A12 Chelmsford to A120 widening scheme

8.3 Statement of Common Ground with Historic England

June 2023

Statement of Common Ground with Historic England

VIEWPOINT 20: Representative view north of PRoW 128_22, and Easthorpe Green Farmhouse (grade II listed)

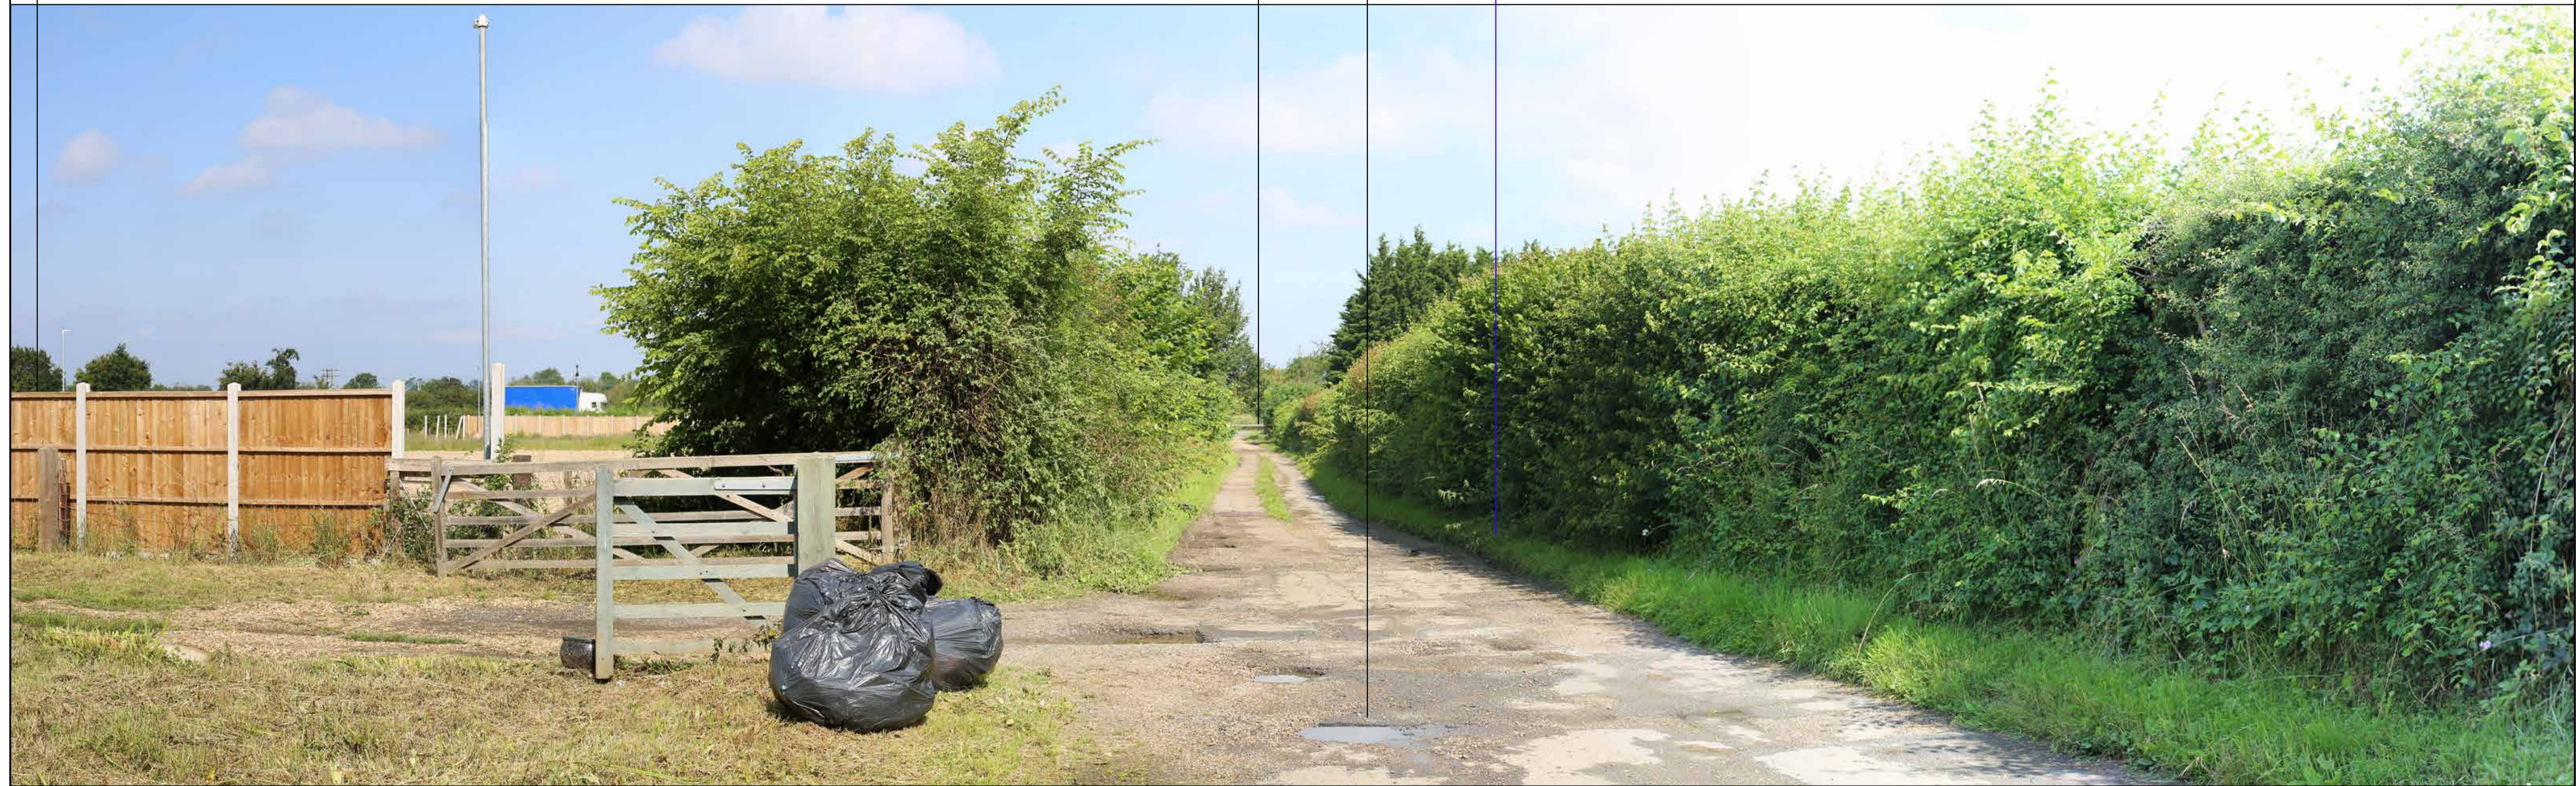
Ref.	Issue	Document Reference	Historic England Position	National Highways Position	Status	Date
	cultural heritage assets		<p>impact the grade II listed buildings at Easthorpe Green Farm (Easthorpe Green Farmhouse and Church View/Flispes). There would also be impacts on the grade II* listed barn at Marks Tey Hall. Associations with historic Easthorpe Green and Potts Green, which form their settings, require detailed assessment in the Environmental Statement.</p> <p>The Environmental Statement should clearly cross-reference to the baseline landscape chapter data. The landscape and visual assessment should include heritage specific viewpoints (photographs, photomontages and wirelines) to illustrate and support the results of the heritage assessment.</p> <p>Setting impacts on heritage assets should not be restricted to visual impacts and should include other factors during construction and operation.</p> <p>The assessment of impacts and mitigation provided for the assets described above is accepted. Consultation on the impacts and proposed mitigation for the scheduled Neolithic long mortuary enclosure at Appleford Farm, Rivenhall End (Asset 399) and medieval moat at Marks Tey Hall (Asset 818), and grade II* listed barn at Marks Tey Hall (Asset 816) is ongoing.</p>	<p>viewpoints, which includes these heritage assets, is presented in Appendix 8.3: Visual Effects Schedule, of the Environmental Statement [APP-6.3], which supports Chapter 8: Landscape and visual [APP-6.1], and was undertaken in accordance with DMRB LA 107 (Highways England, 2020). Historic England has also been consulted on these representative viewpoints. Appropriate mitigation measures in accordance with DMRB LA 106 (Highways England, 2020) have been developed and included in Section 7.10 of Chapter 7: Cultural Heritage [APP-6.1] and Appendix 7.9: Cultural Heritage</p>

Ref.	Issue	Document Reference	Historic England Position	National Highways Position	Status	Date
				<p>Impact Summary Tables of the Environmental Statement [APP-6.3].</p> <p>Impacts from other aspects such as noise and groundwater have also been taken into account in Section 7.11 of Chapter 7: Cultural Heritage of the Environmental Statement [APP-6.1].</p> <p>Historic England's concerns regarding impacts on the settings of the scheduled Neolithic long mortuary enclosure at Appleford Farm, Rivenhall End (Asset 399) and medieval moat at Marks Tey Hall (Asset 818), and grade II* listed barn at Marks Tey Hall (Asset 816) are addressed below at Ref. 2.6.</p>
